Ecology response

From: Jonathan Best <Jonathan.Best@arun.gov.uk>
Sent: 01 July 2025 13:58
To: Planning.Responses <Planning.Responses@arun.gov.uk>
Cc: Harry Chalk <Harry.Chalk@arun.gov.uk>
Subject: WA/44/25/PL

Longacres Eastergate Lane Walberton BN18 0BA.

PROPOSED DRAWING 2a
Site Plan
November 2024
1:200 at A3

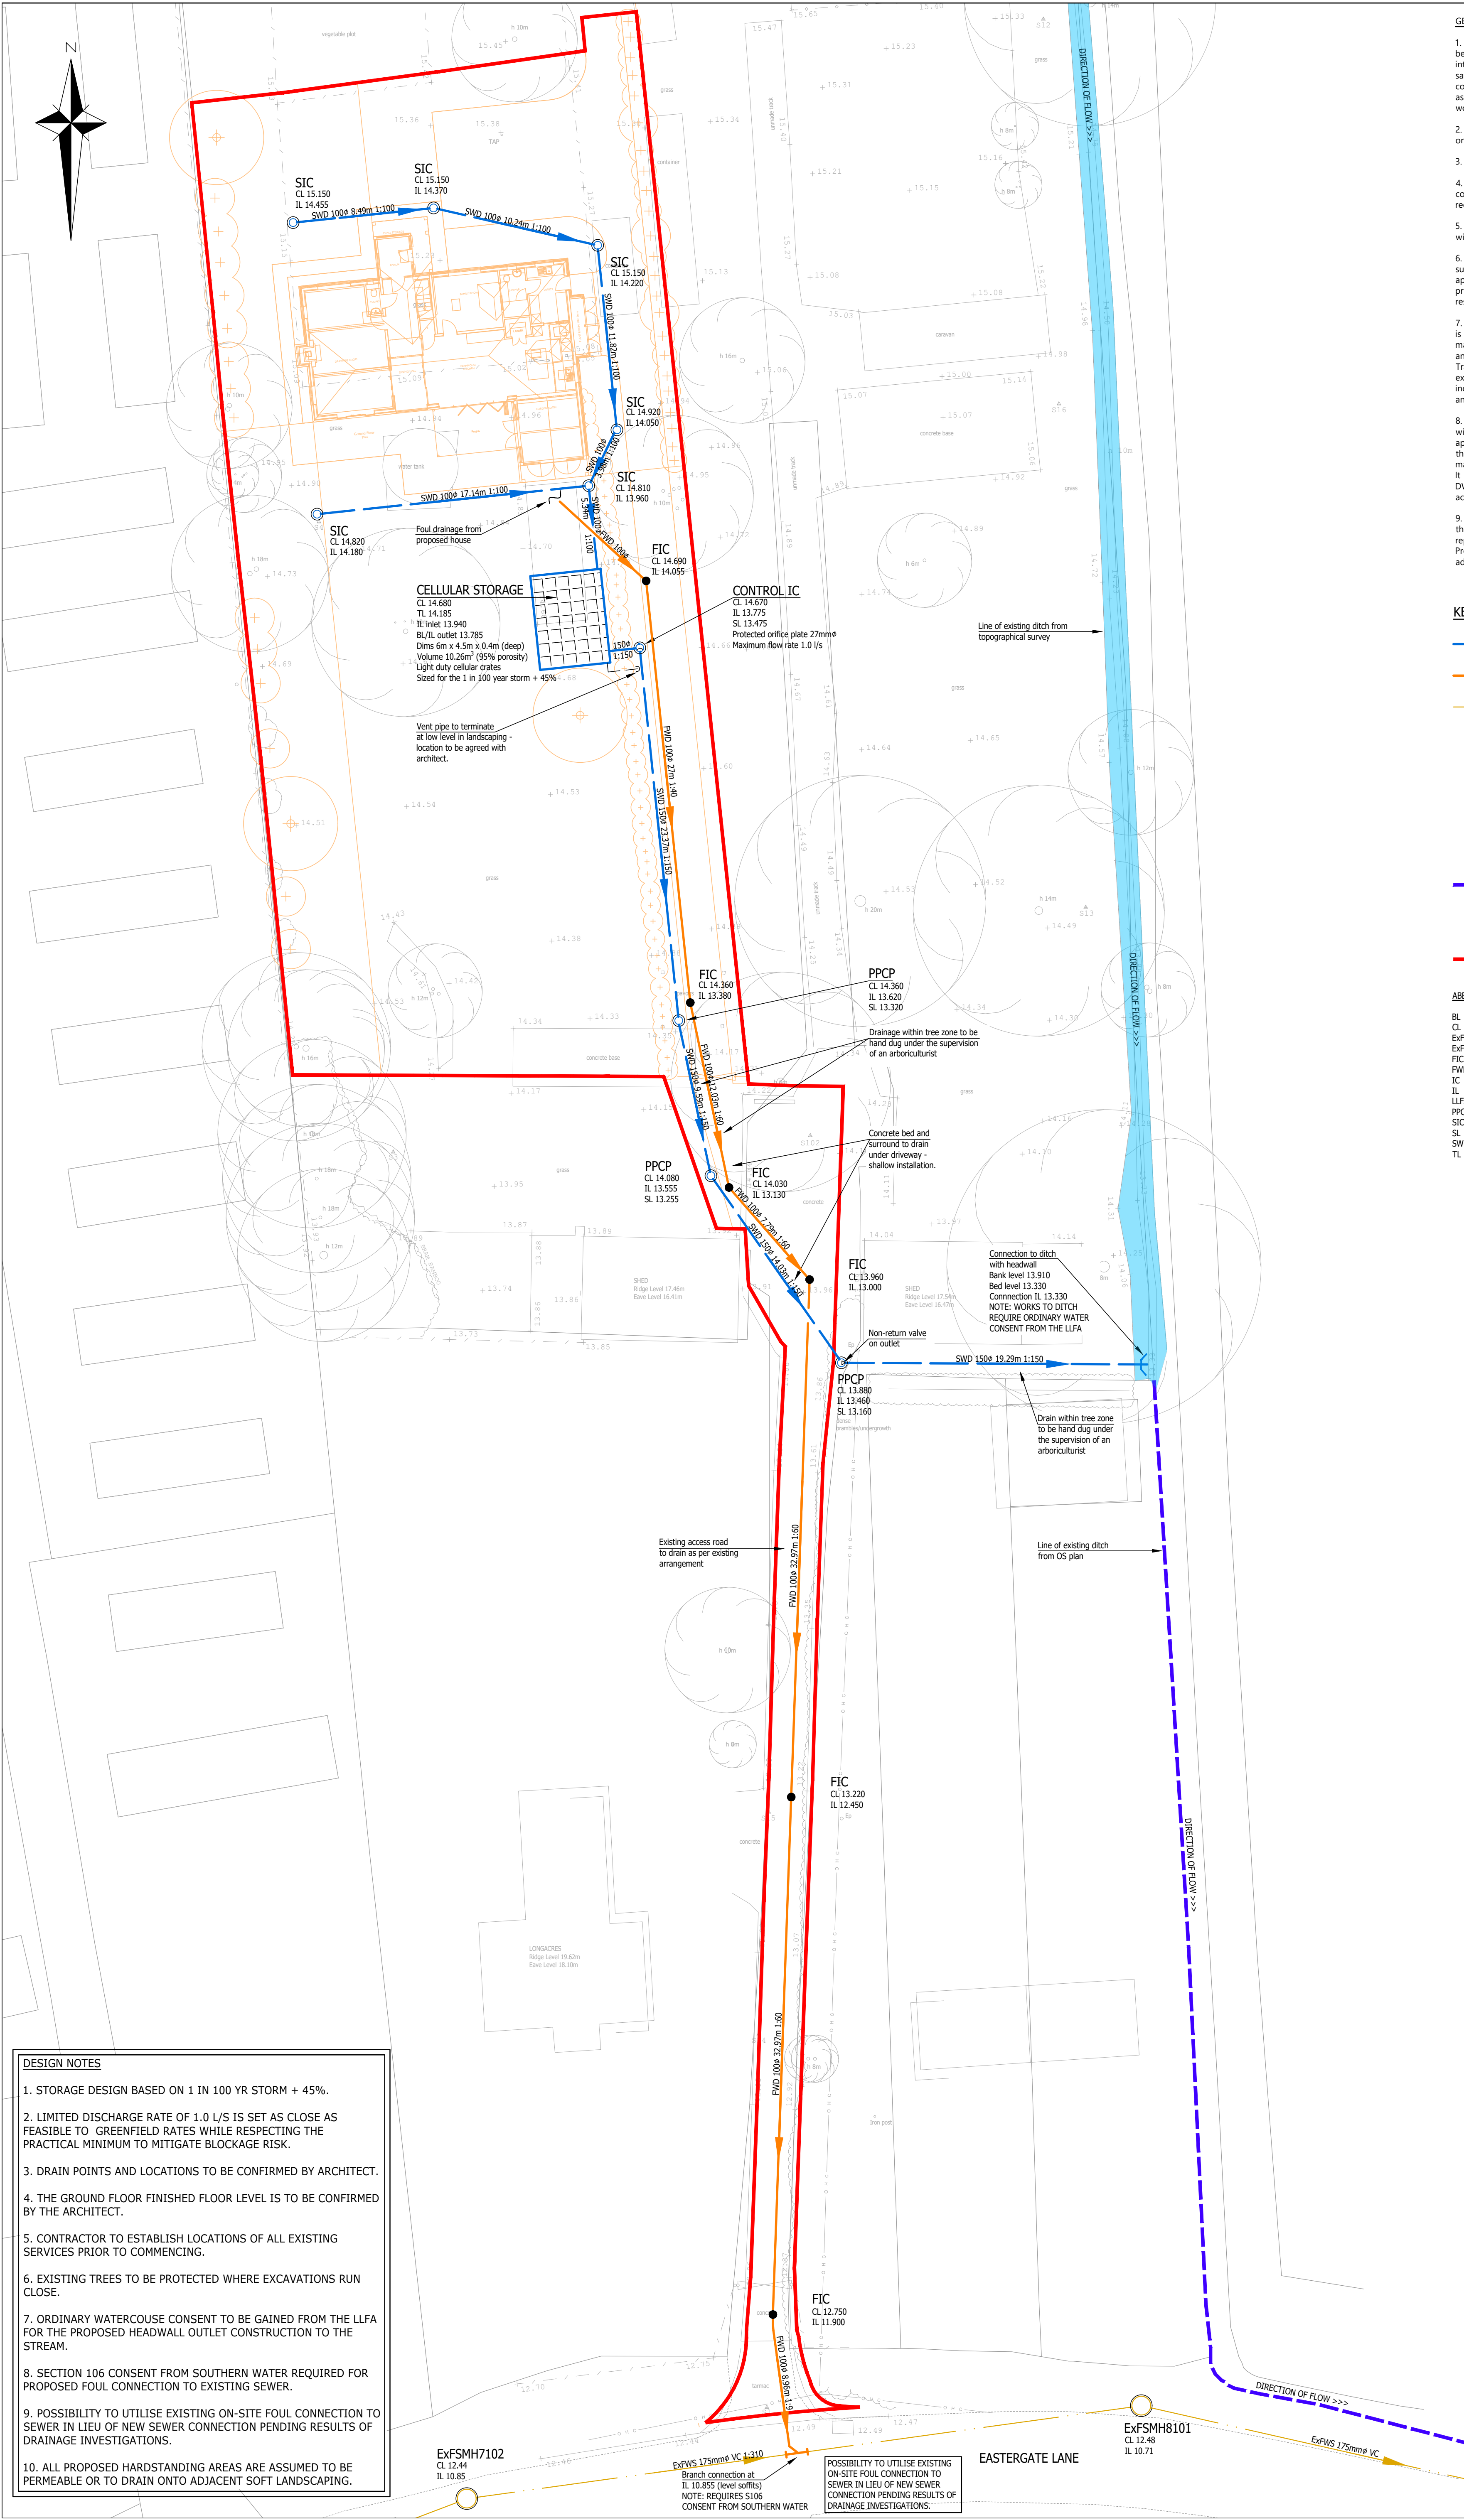
The nest boxes are located on the northwest of the house I advise relocating to the northeast to prevent the boxes overheating.
